DOC19/31623

Bobs Farm Sand Mine (SSD 6395)

Thank you for the opportunity to provide comment in relation to the proposed sand mine operation adjoining Bobs Farm Public School.

Figure 15-1 - Barrier Impacts at the main Egress Point on Marsh Road

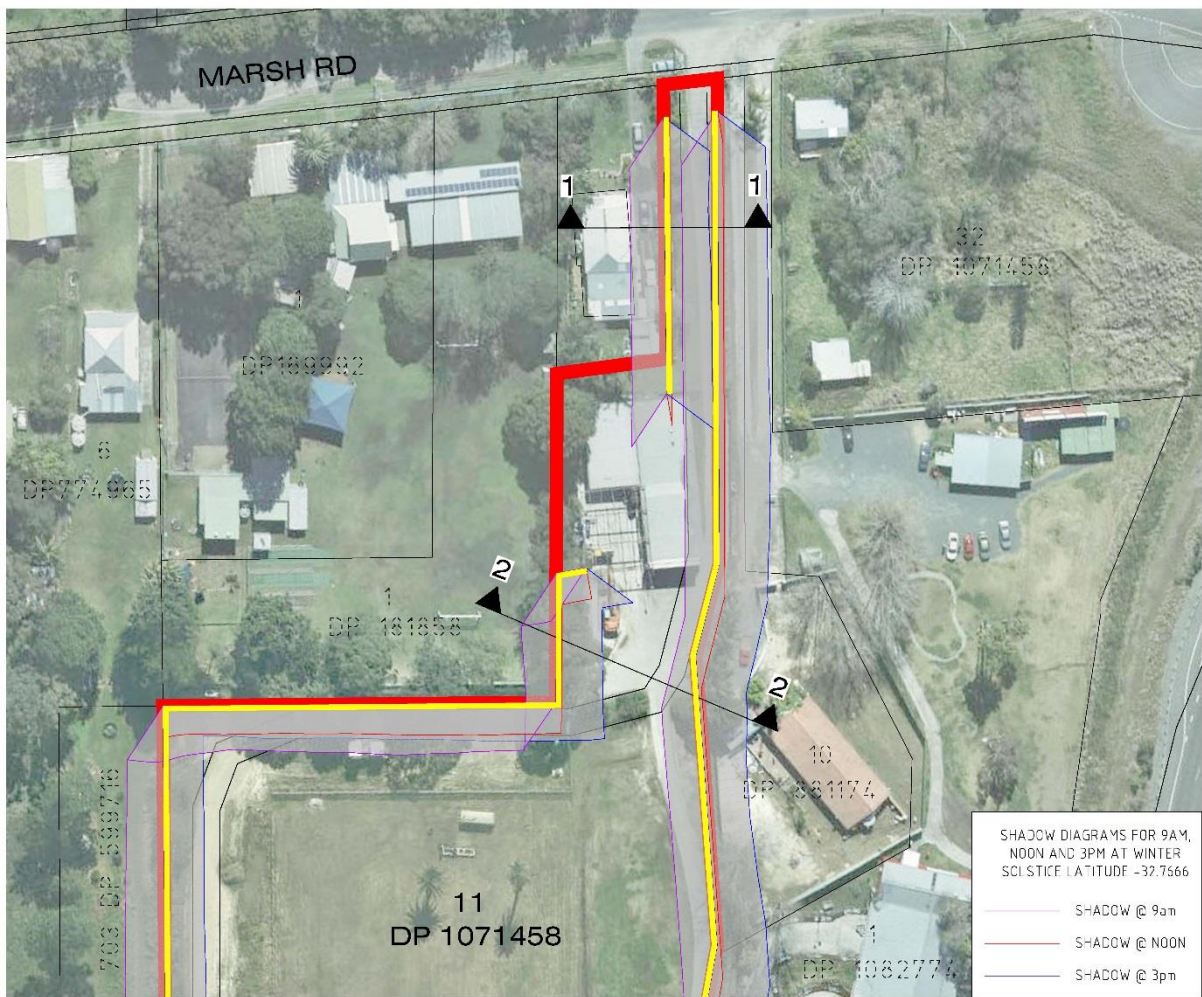
The EIS noise impact assessment proposes, as a measure against likely exceedances of regulated noise levels, to erect a 4 metre high noise barrier around the site and near the school. This structure is lacking in detail and needs to be assessed for its own potential impacts, such as visual amenity, and to confirm its noise mitigation properties and the maintenance responsibilities over the life of the development.
